Hearing Transcript

Project:	Lime Down Solar Project
Hearing:	Issue Specific Hearing 3 (ISH3) – Part 3
Date:	2 July 2026

Figure 3-2: Key Construction Phase Features

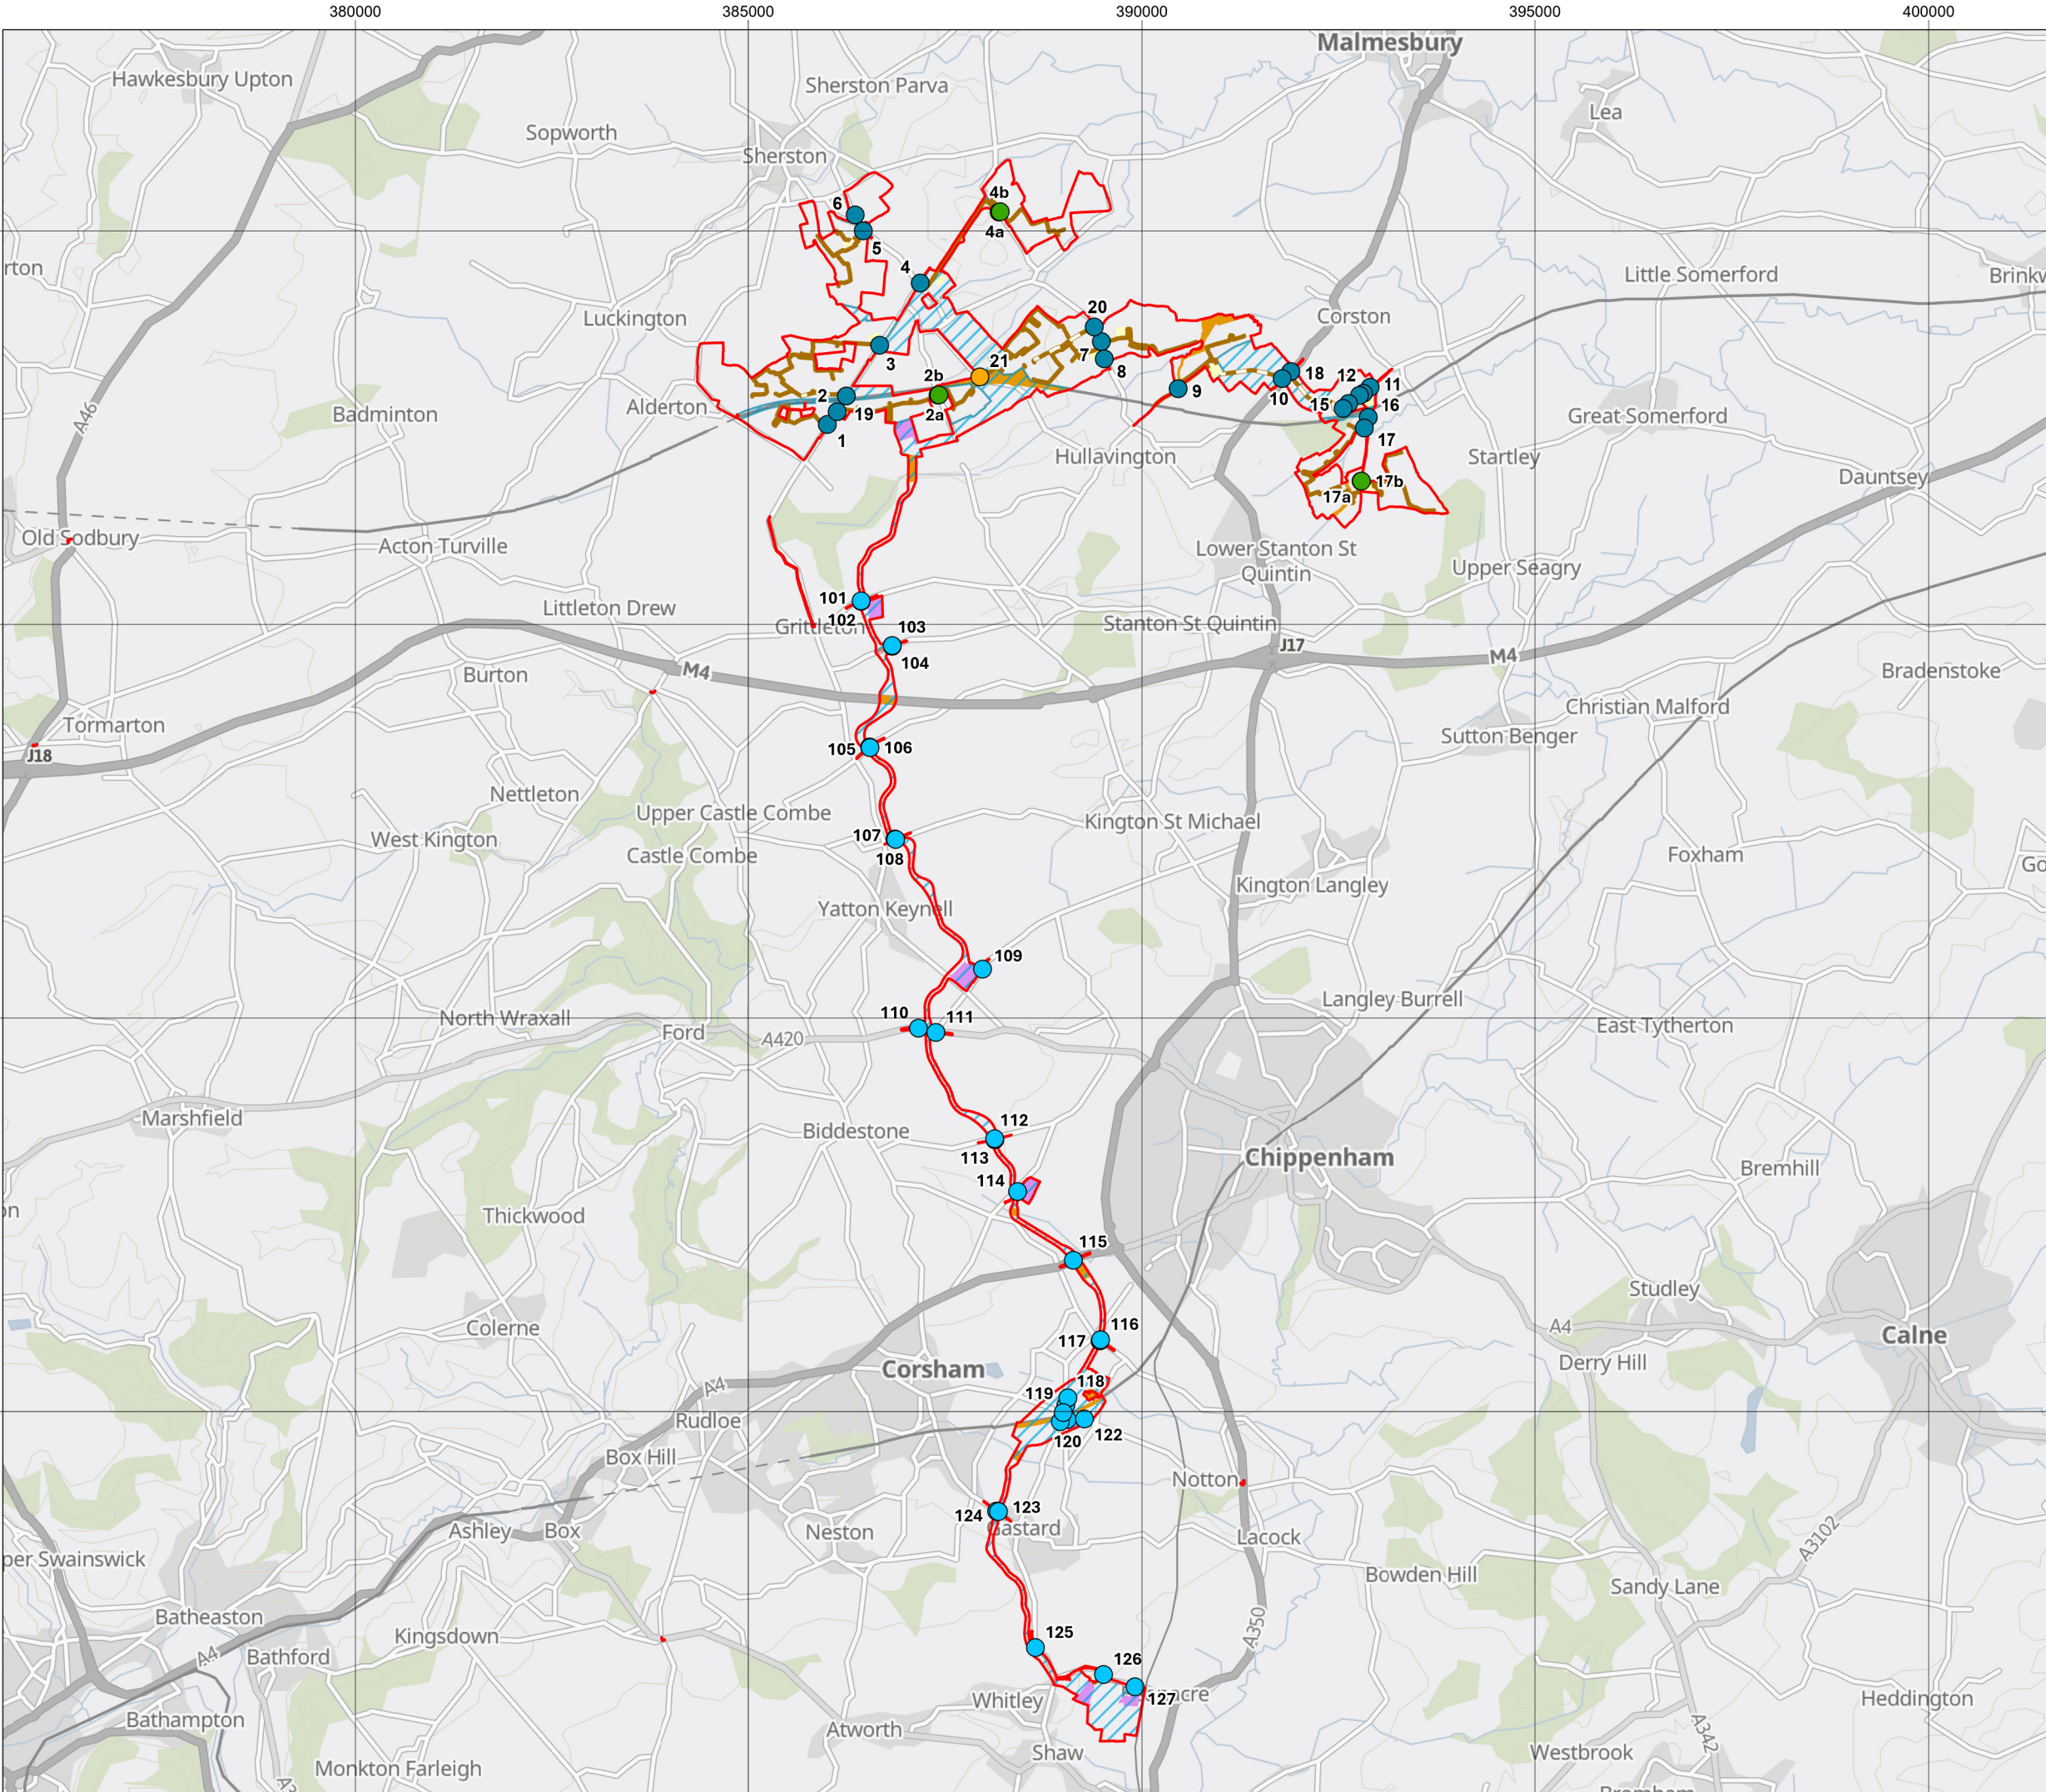
our surveys, we, we looked at, um, where, uh, habitats that may be particularly sensitive or, you know, particularly affected by, by siting temporary construction compounds. And the surveys were, you know, identified that the, the eventual location of those compounds were on habitats which were relatively low value for biodiversity. Um, they were sort of arable fields and species, poor, uh, agricultural grasslands. Um, we also considered during the course of the habitat surveys considered where um identified uh watercourses suitable for migratory fish, which we felt were particularly

sensitive to cable installation works and where any watercourse was identified, which is which we've we've we assessed the suitability for migratory fish.

They are included in um avoidance areas which are located on the plan um one seconds prep 3036 key construction phases. Features. Figure two two structure phase features. Um. And those avoidance areas are locations where cable installation will adopt trench loss techniques, such as horizontal to actually horizontal directional drilling to avoid directly impacting, um, those features.
